# **SUBMISSIONS REPORT**

SSDA-10448 Mod 3 & SSD-46516461 WH9  
Aspect Industrial Estate

Prepared for  
**MIRVAC**

1 LOT 9 EAST ELEVATION
1 : 500

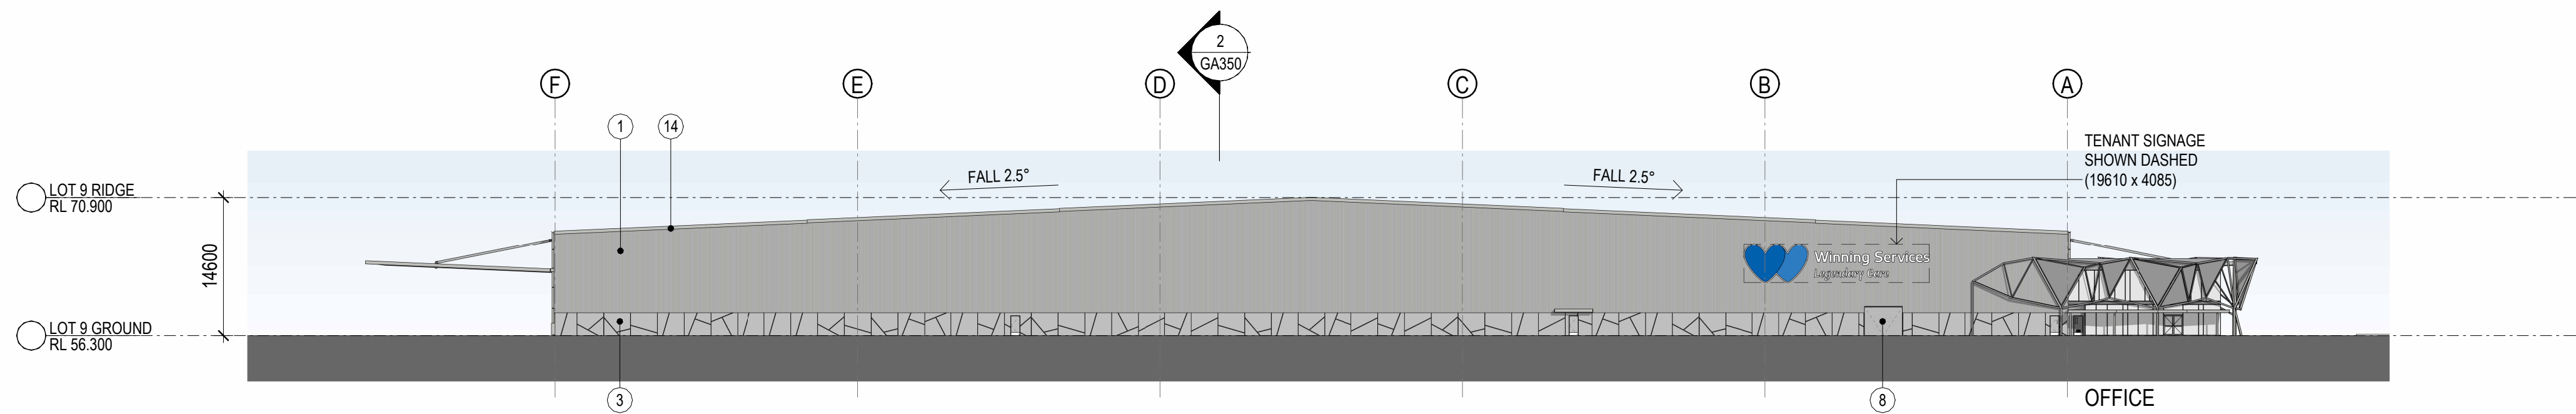
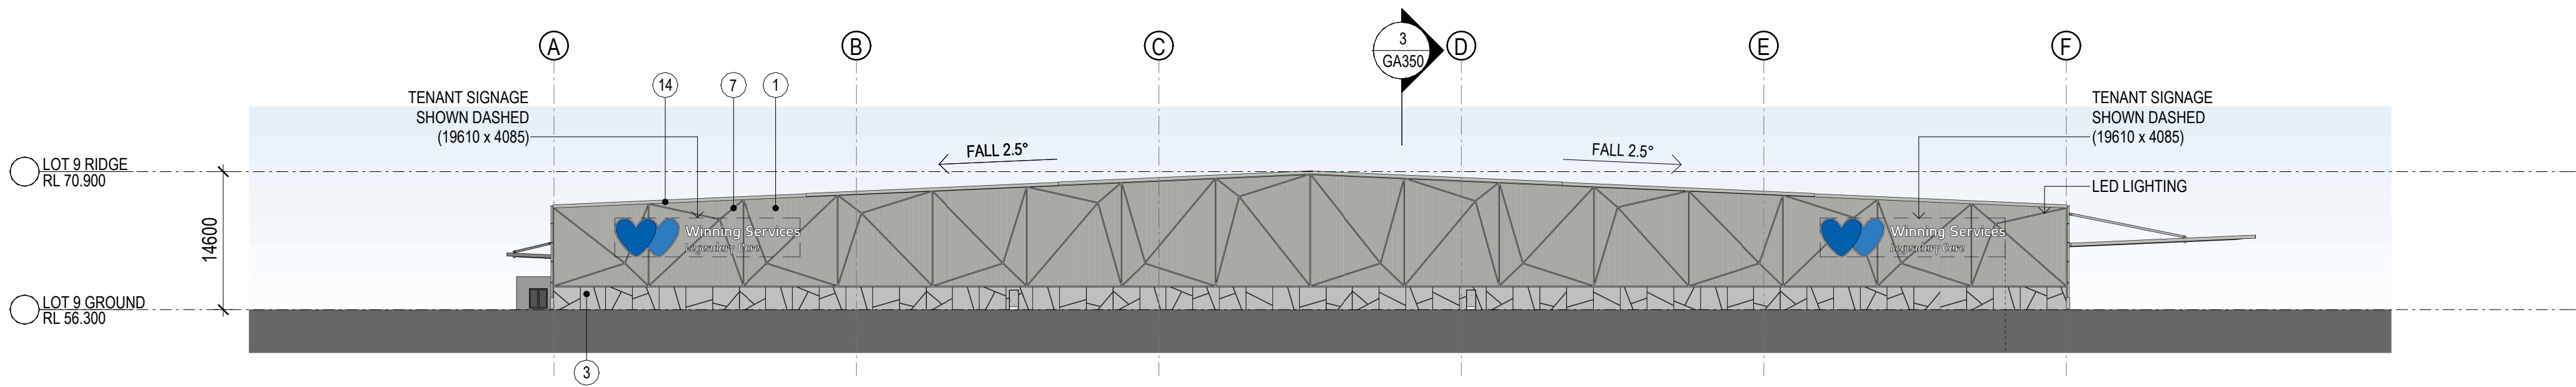
The scale of the materials and colours is too small to interpret. It appears that the whole building, including the office will be grey (or various shades of). DPE is to review and assess if appropriate. A larger scale material and finishes schedule may be required.	<p>Building forms have been developed from the original Architectural Concept detailed in the Design Statement approved as part of the Initial SSD DA. Image 1 and 2 below have been extracted from the Design Statement. As indicated in SSD-10448 EIS Appendix E Architectural Concept Report, the offices are wrapped in perforated metal screens providing dappled shaded areas, under a “canopy.” The colour palette used on the facades of the buildings reflects the Australian landscape and is concisely muted, natural and restrained.</p> <p>The jointing in the concrete base represents the tree trunks, while the articulated cladding represents the trees with its multi-faceted branches. The offices are wrapped in perforated</p>	<b>Appendix B</b>

Summary of Issue Raised	Response	Supporting Document
	 <p>The muted light grey and white metal cladding will help to reduce the overall visual impact. The elevations to Mamre Road include decorative channels on the warehouse cladding and precast concrete to provide visual interest and break up the elevation whilst maintaining consistency with the overall estate.</p> <p>The building finishes and colour scheme have been selected to ensure durability and low maintenance for site personnel as part of Mirvac's ongoing commitment to safety in design and legacy.</p> <p>An additional northern elevation artist impression has been prepared to demonstrate the intended design of Warehouse 9. As estate bulk earthworks are now under construction (as approved under the original SSD DA) an artistic impression has been created from Access Road 3 as it is not possible to provide a photomontage from this location. The artists impression is based on the proposed Warehouse 9 3D architectural model and reflects landscape plans and tree species.</p> <p><i>Note: the artists impression does not detail the Lot 7 warehouse which will be subject to a future development application and zone substations which are subject to separate applications with Endeavour Energy.</i></p> <p>Image 1: Northern Elevation Artists Impression:</p>

Title
**TYPICAL SECTIONS
SHEET 1**

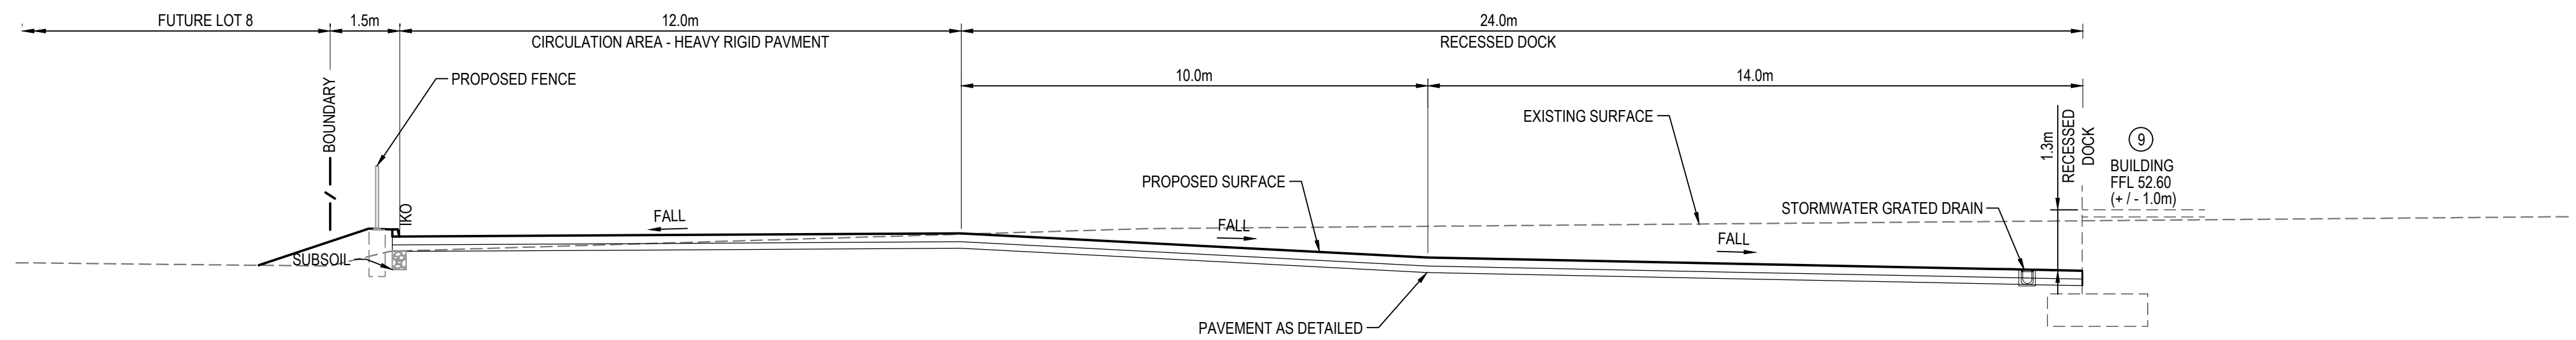
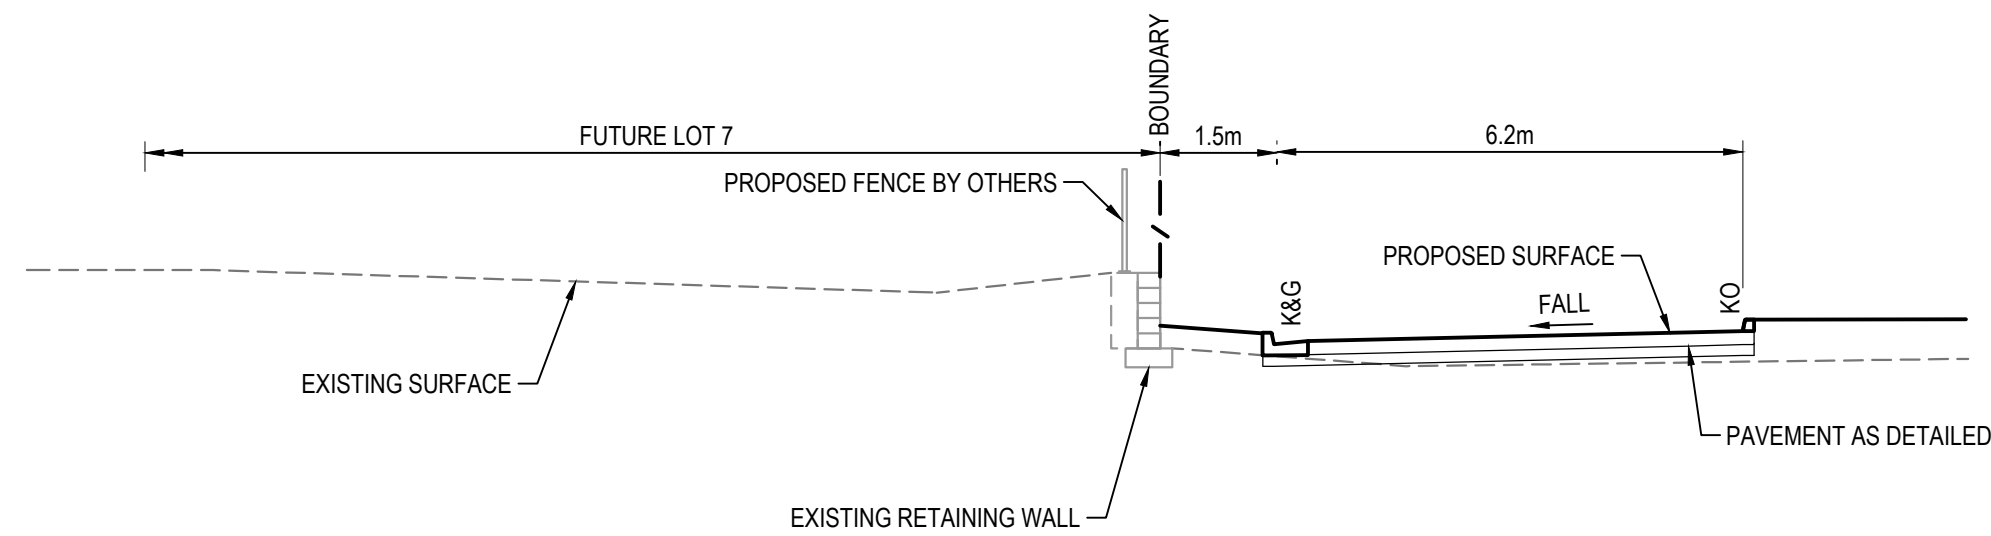
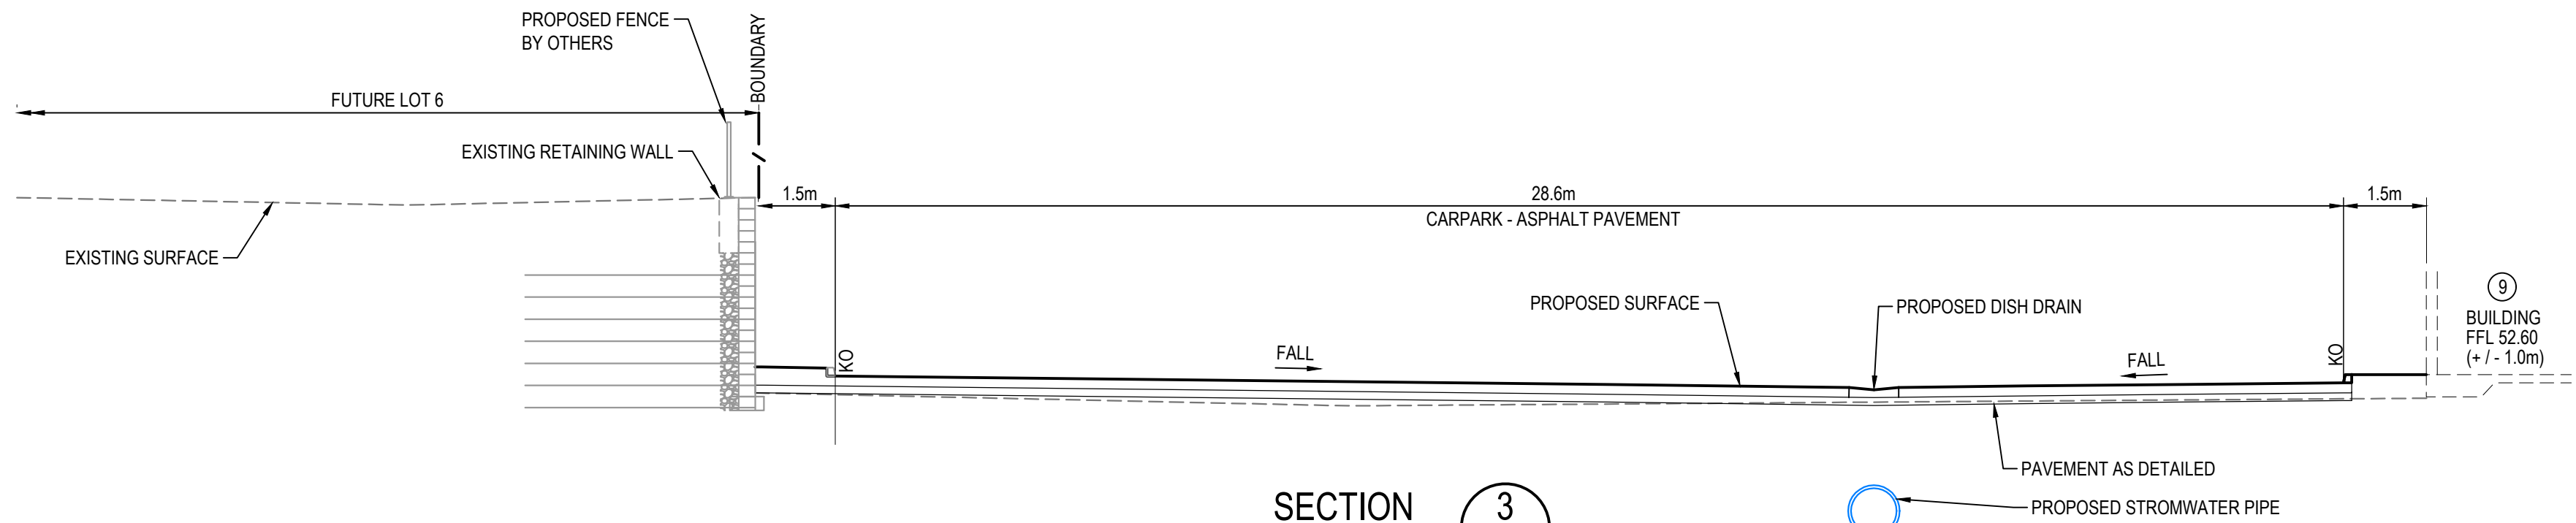
Civil sections across the estate include 1200mm wide concrete dish drains and catch drains within areas for landscaping which in some instances impact viability of	Sufficient space is provided for tree plantings, accounting for the 1200 dish drain.	<b>Appendix D</b>
